Your Ref: OWPC16221
Our Ref: FG/172/17/HH 03-11-2017
Please ask for:
Mark Jones

Single storey rear extension.

5 Sark Gardens Ferring

PROPOSED ELEVATIONS 1:100@A3

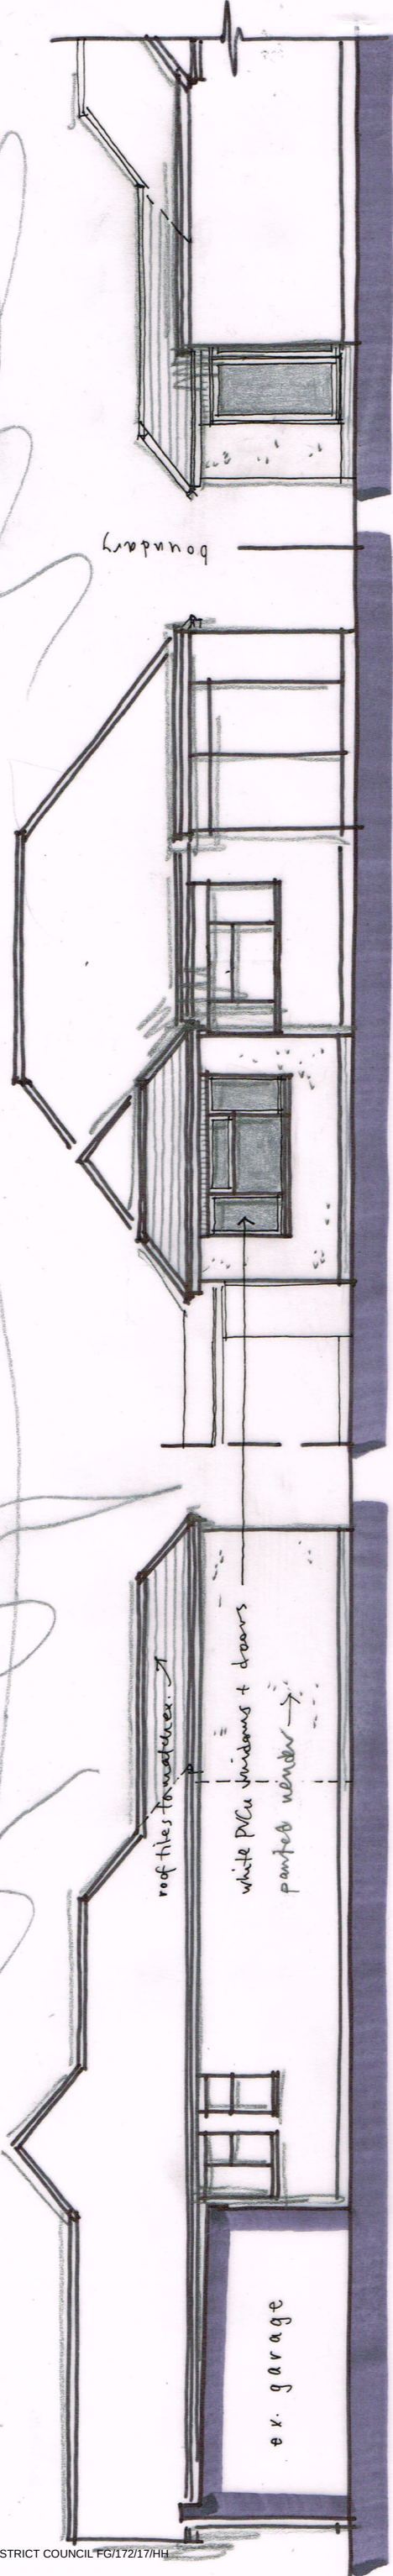
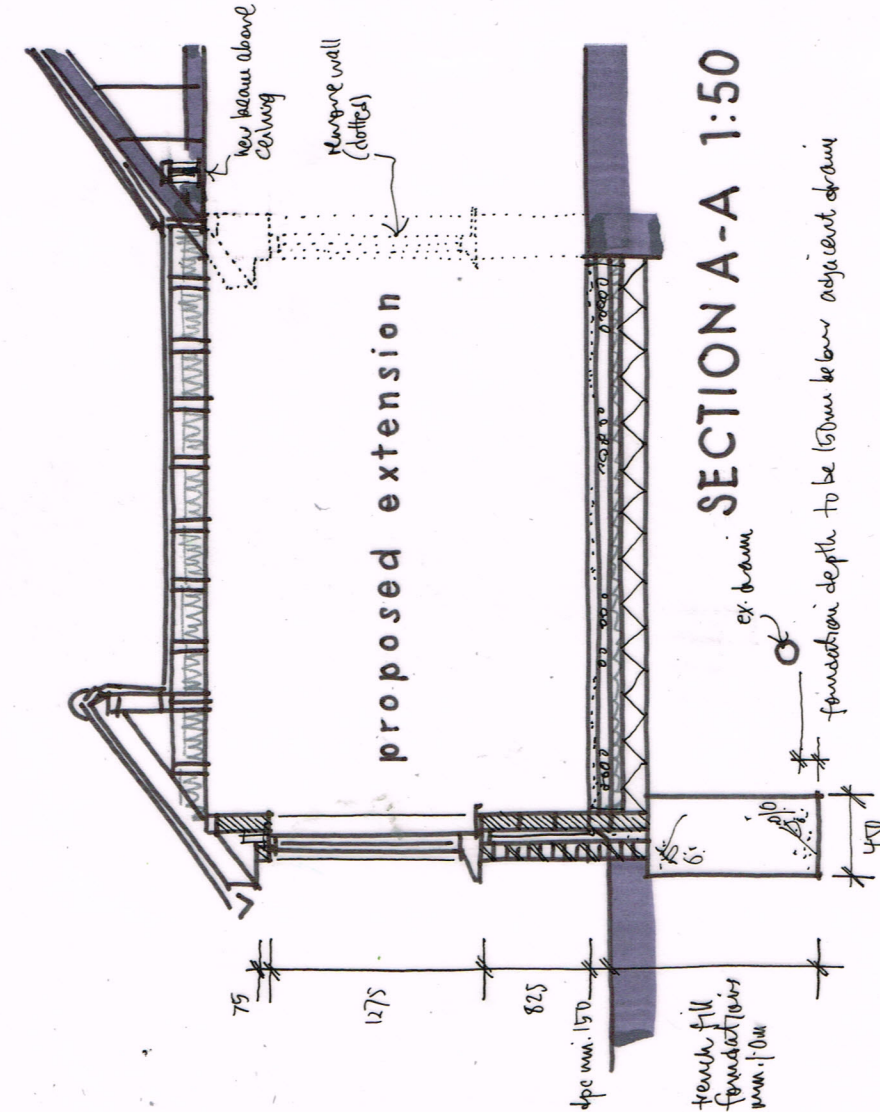
The extension is not in brick and should be to reflect no change to existing and match the adjoining property.

Roof tiles should match the existing.

GROUND FLOOR PLAN 1:50

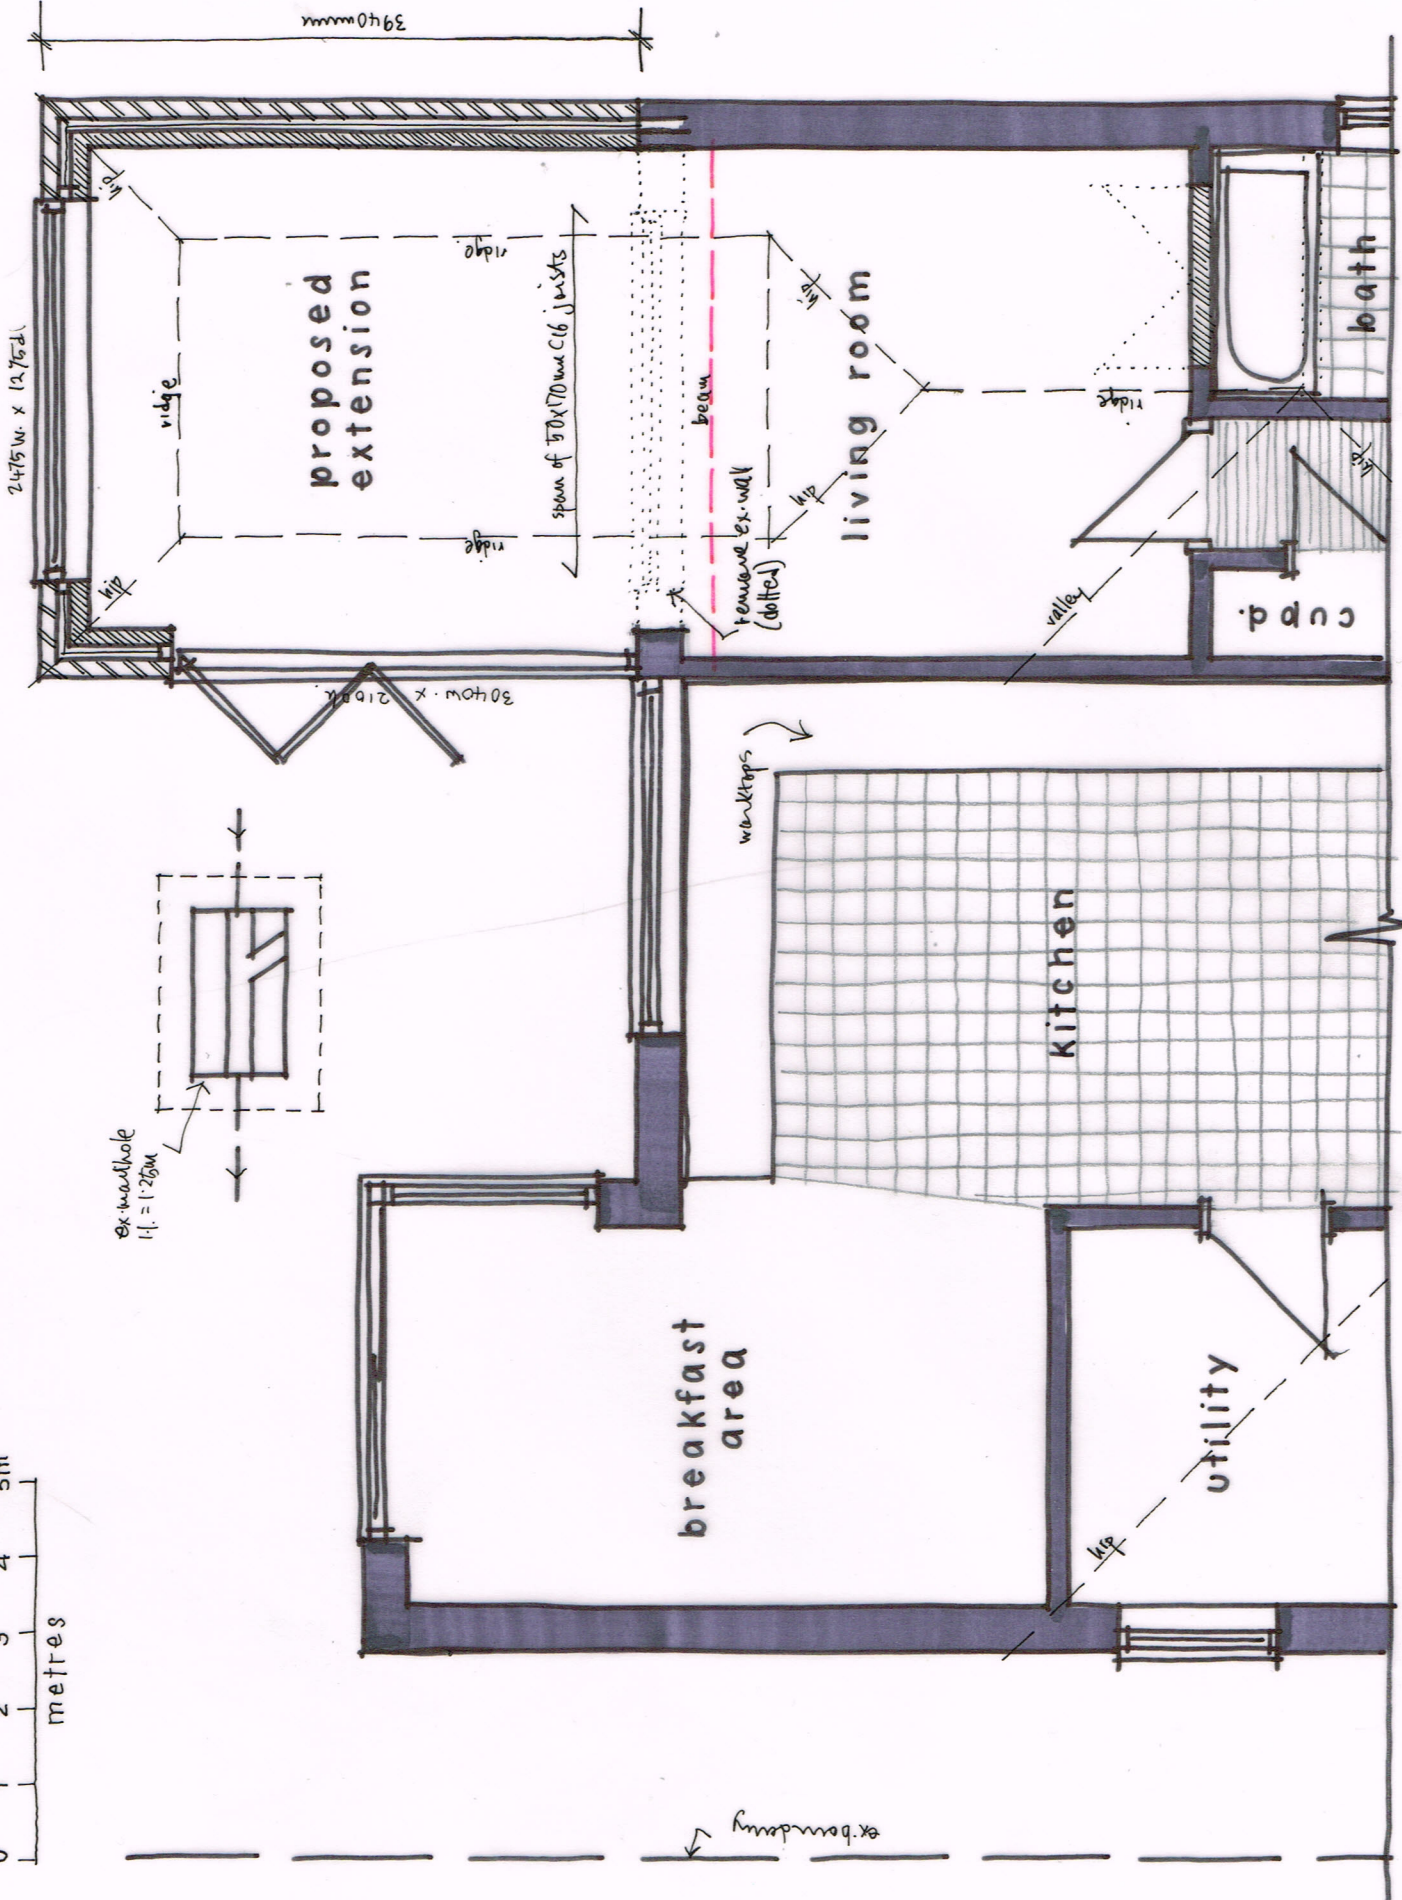
The application only appears to show the ground floor without any bedrooms or revised access to rooms in the roof. The extension is built over the existing drains and therefore needs to comply with Southern Water regulations as other properties use the shared drains along that run. Properties in the location do suffer from blockages therefore full access is essential.

The floor plan must show the layout to include bedrooms and stairs to bedrooms clearly that is the intention to increase the occupancy which I would object to in any case as the intention to make a 2 bed bungalow much bigger by stealth.
